CUMNOR PARISH COUNCIL

BOTLEY WEST SOLAR FARM (BWSF) REF: EN010147

Cumnor Parish Council's Comments for Deadline 3 on submissions received by Deadline 2

Botley West Solar Farm
 Statutory / Non-Statutory Sites and Features
 of Nature Conservation
 Sheet 13 of 24

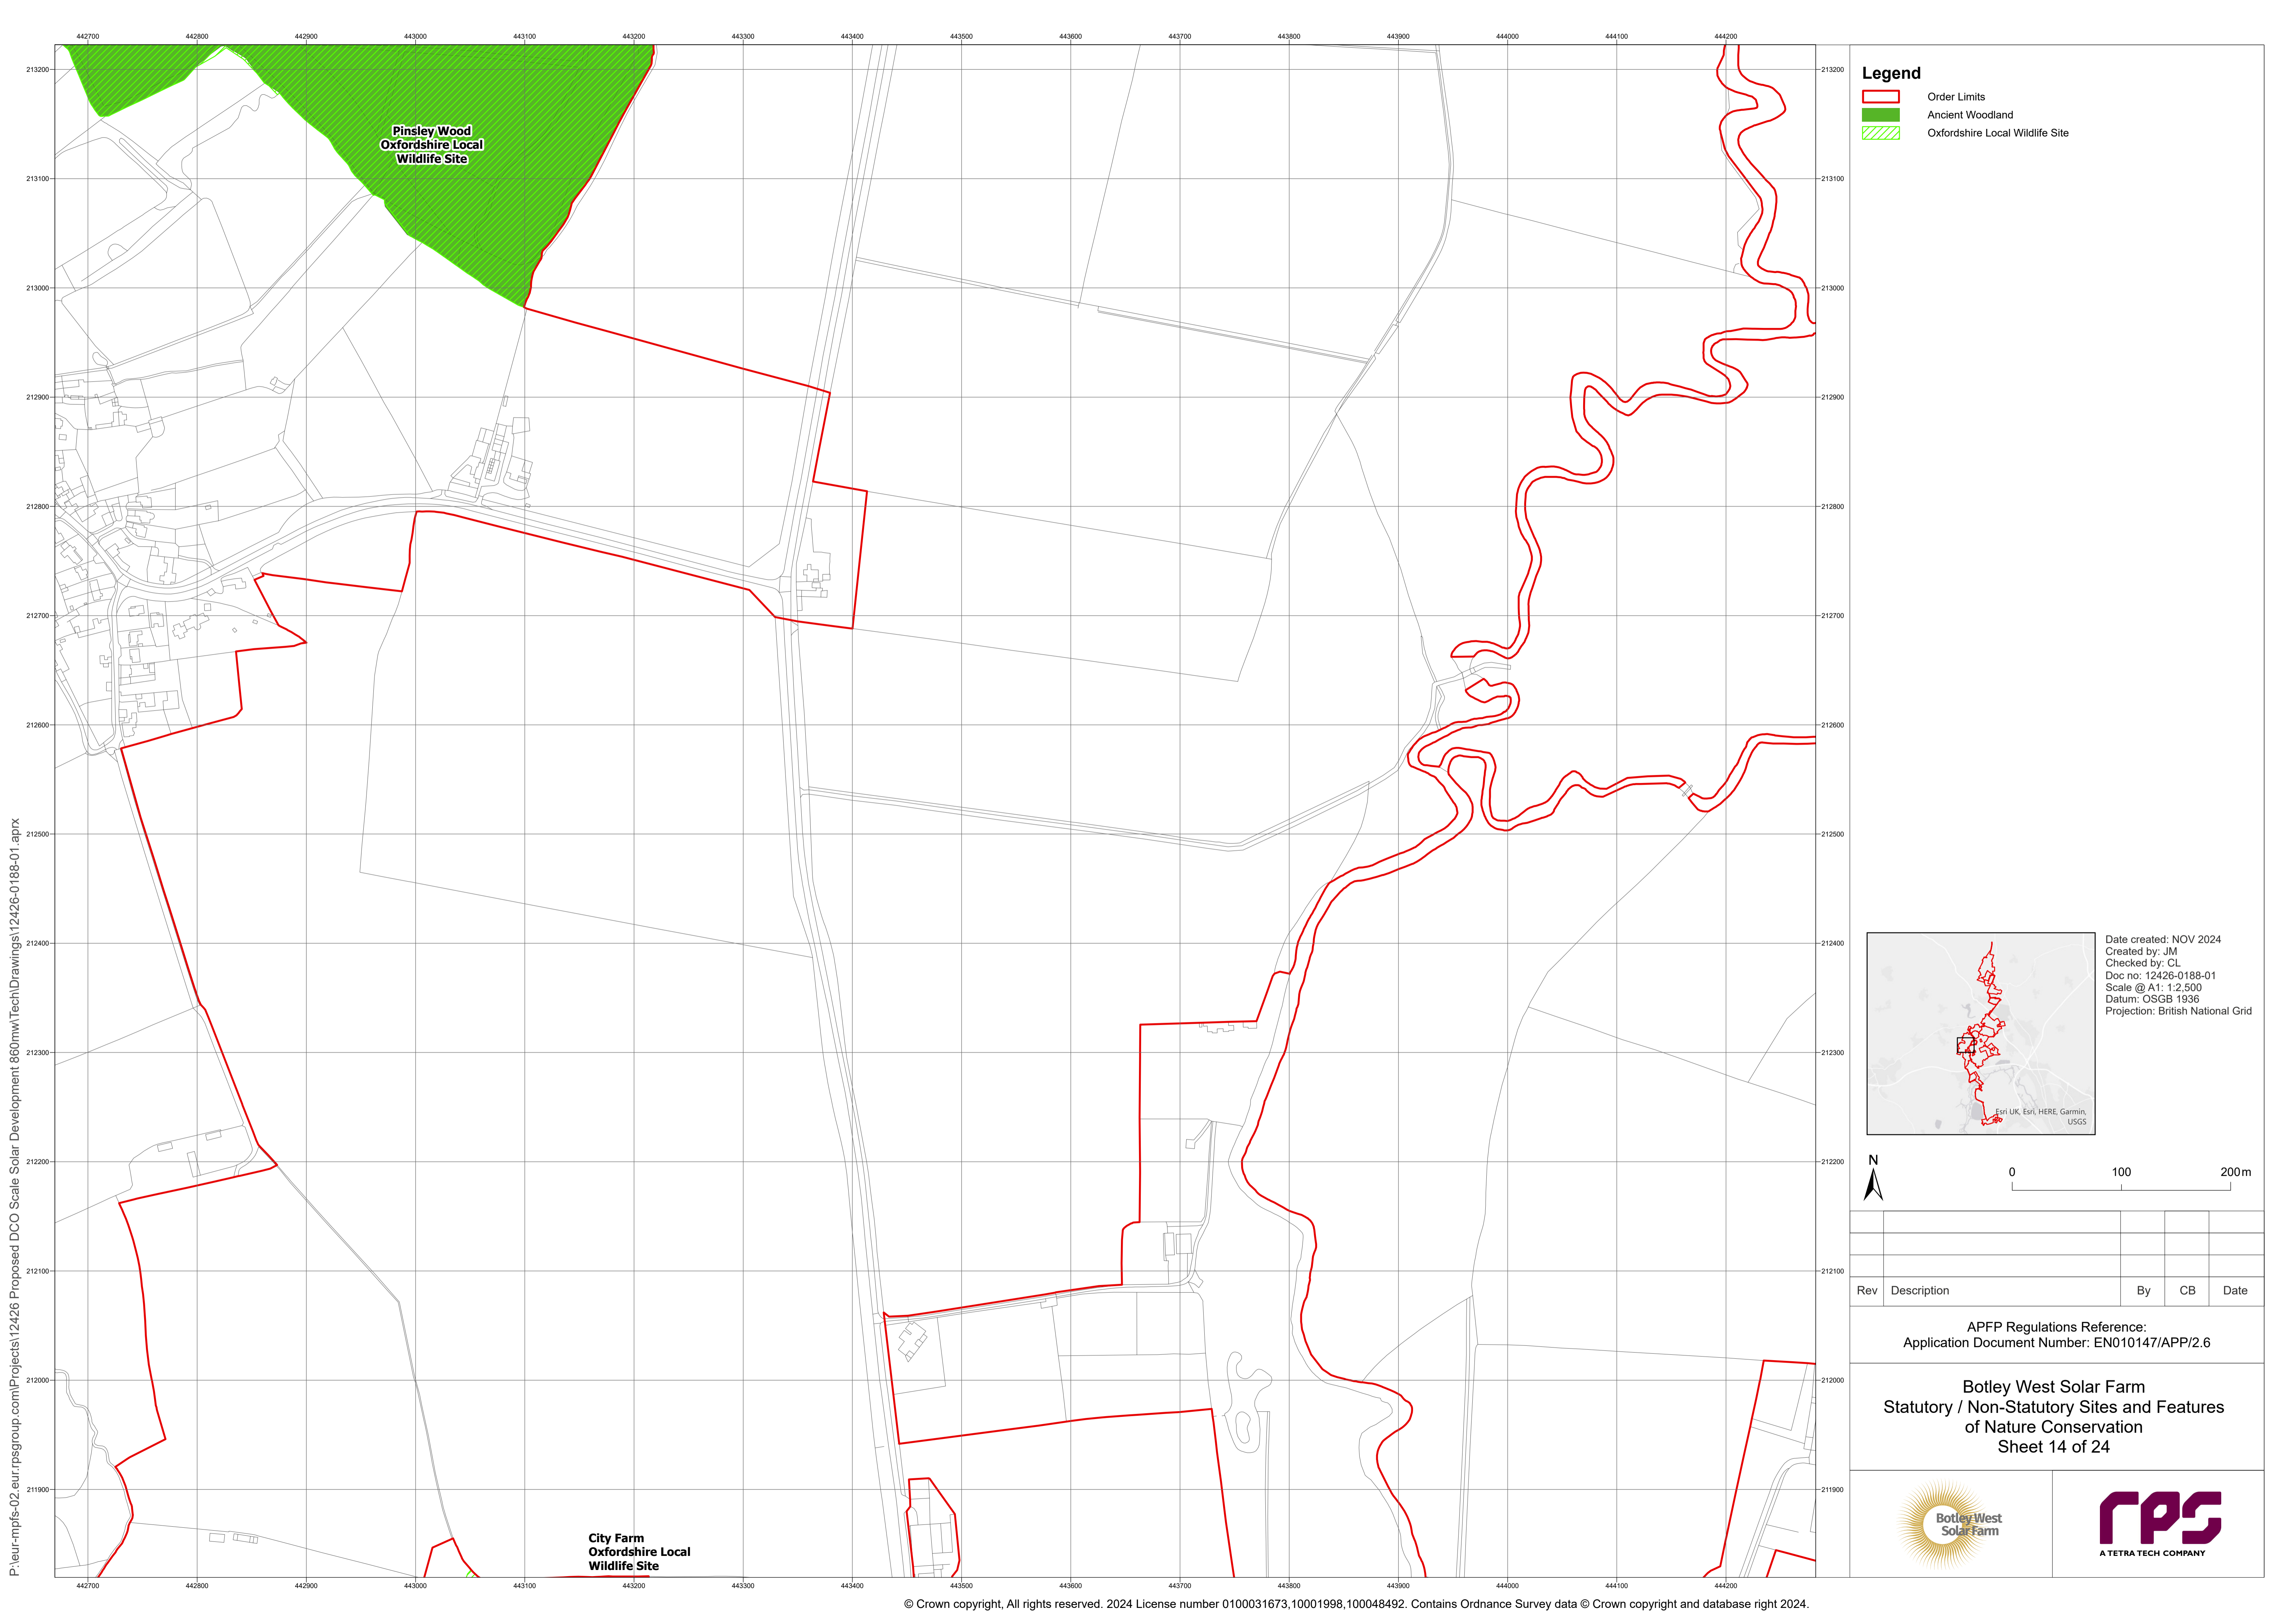
15. REP1-189 – Rebuff based on REP1-062 regarding viewpoints made in document 12.4
16. Hedgerow document sheet 13 details plan. CPC objects to the removal of historic hedgerows and the impact to site ecology.
